**DRB CASE NO/PROJECT NO: 1004319**

Sketch Plat

**CITY OF ALBUQUERQUE  
PLANNING DEPARTMENT  
July 20, 2005  
DRB Comments**

**RE: Sierra Azul/sketch**

**SKETCH PLAT
OF PROPOSED VARIANCE
LOT 33, BLOCK 2
SIERRA AZUL SUBDIVISION
ALBUQUERQUE, BERNALILLO COUNTY, NEW MEXICO
JUNE 2005**

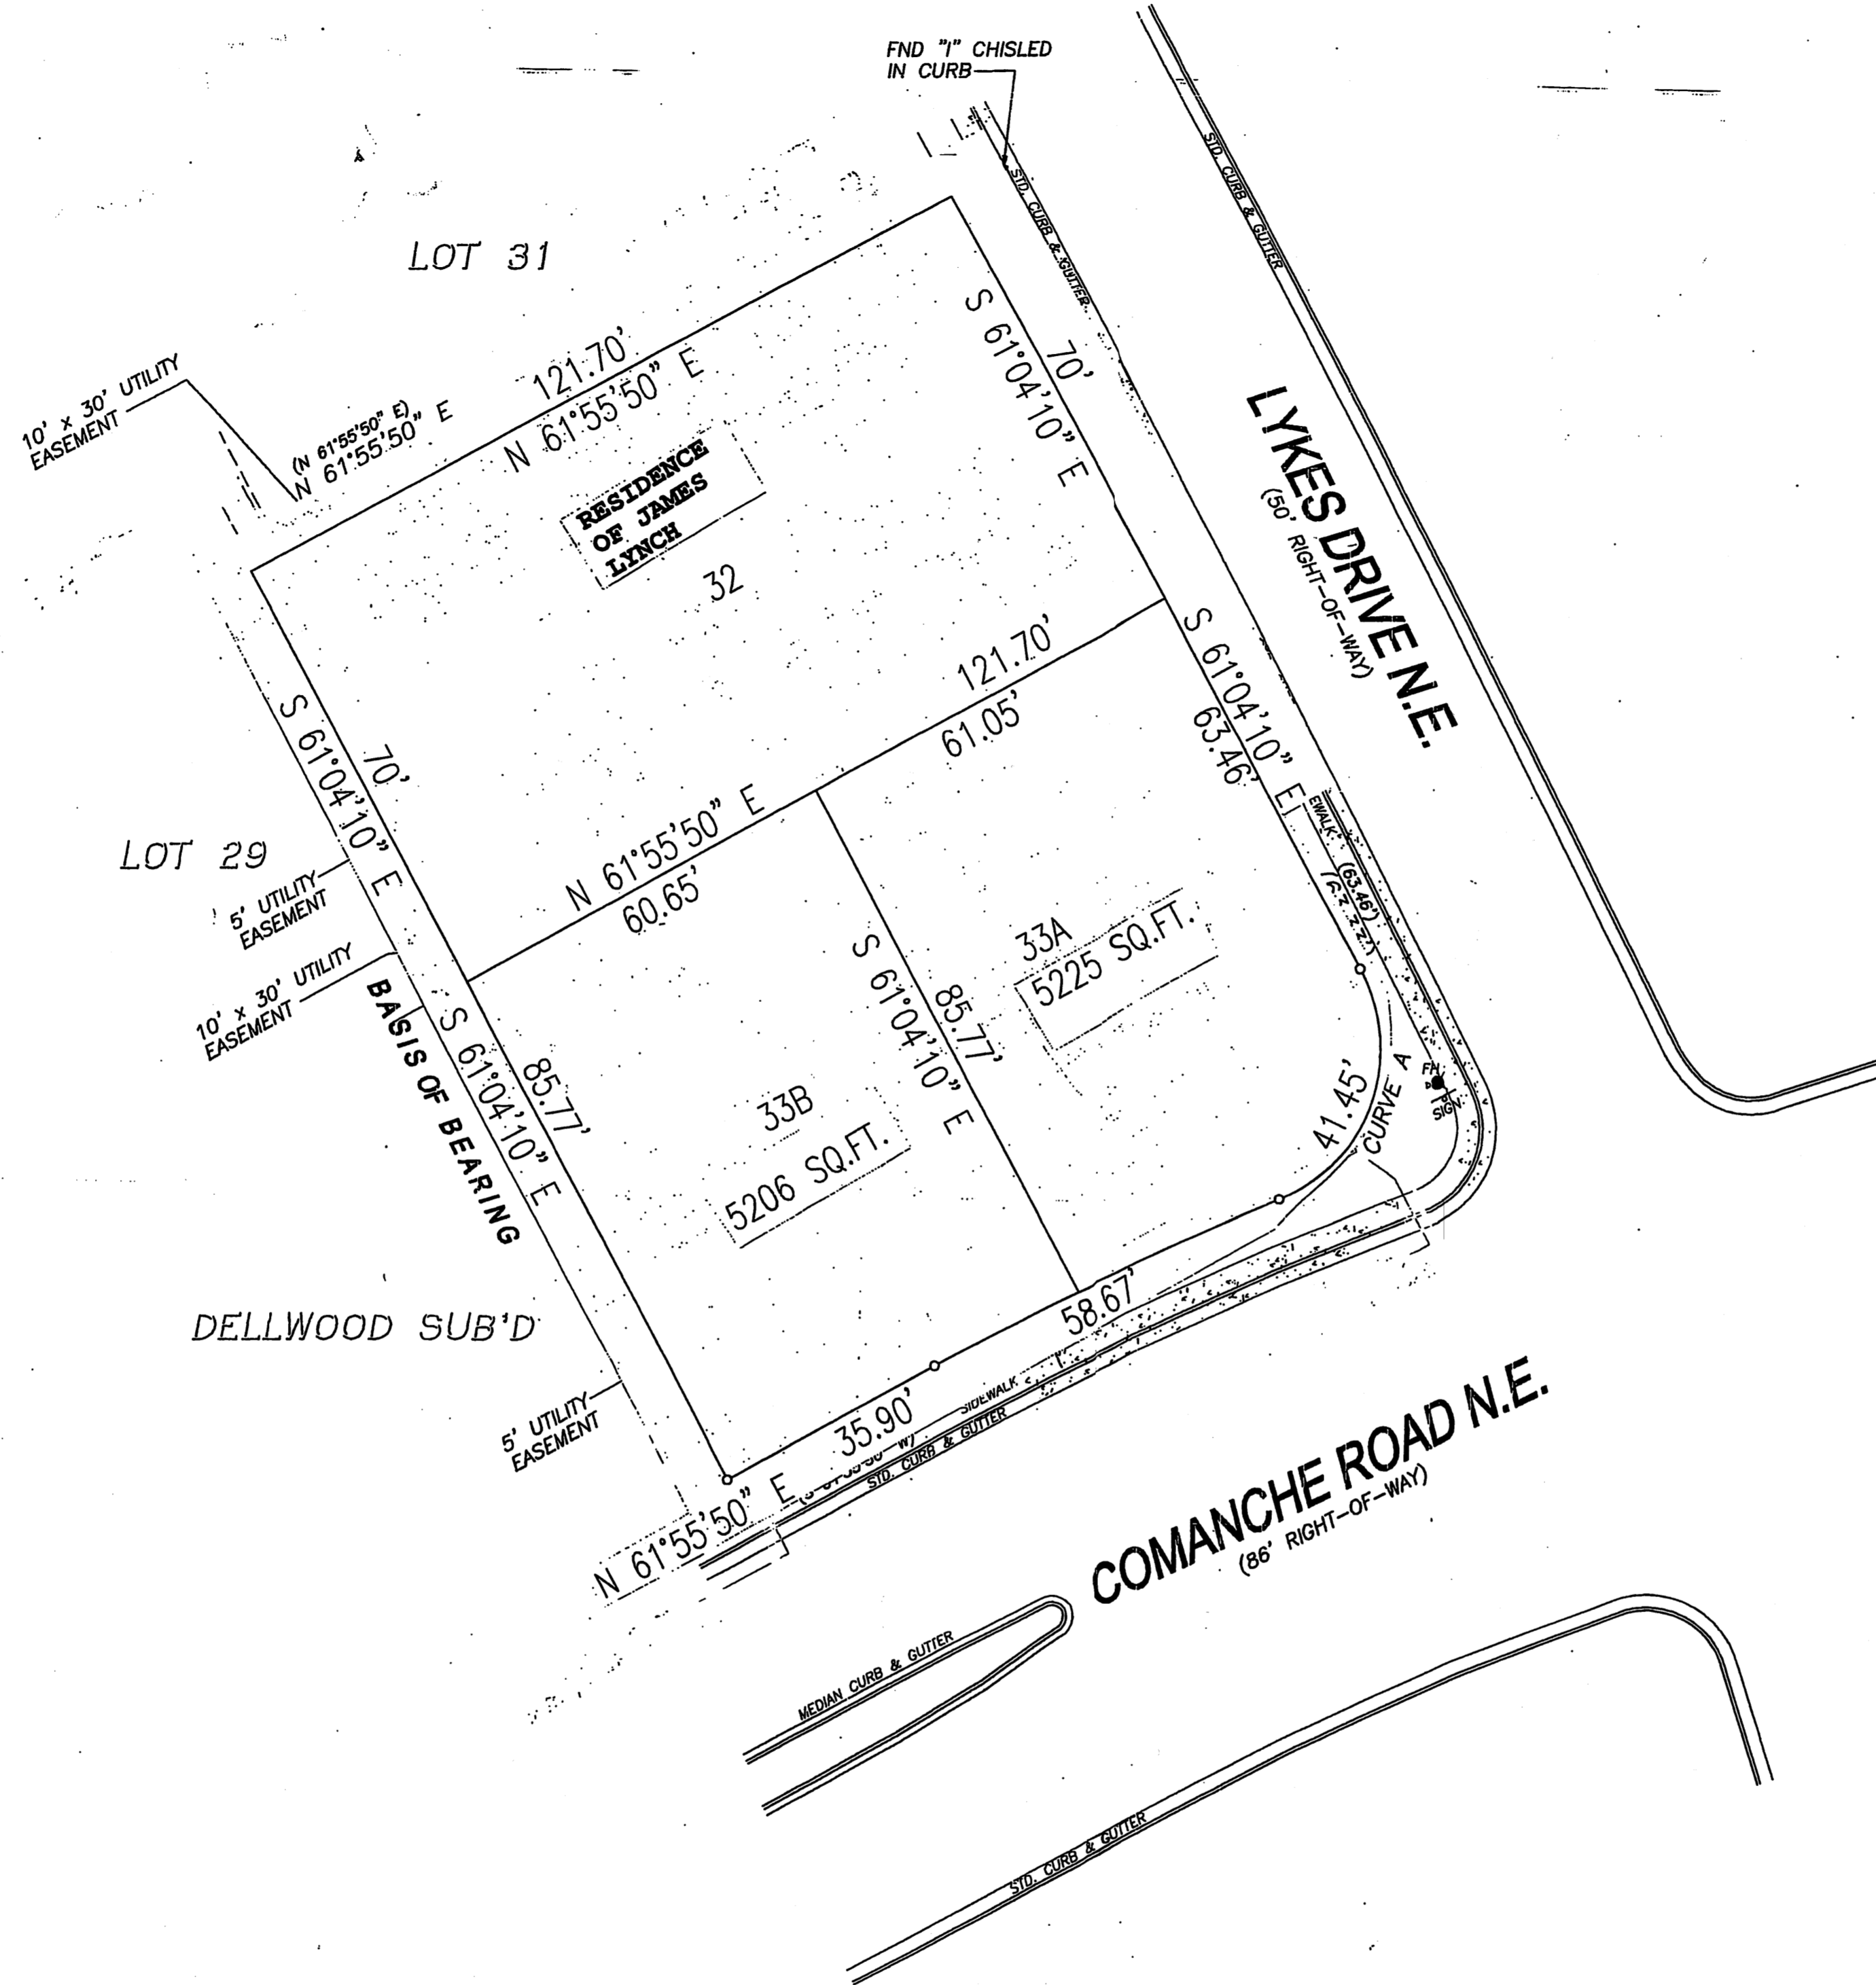
No objection to this request.

Request meets R-1 lot size requirements.
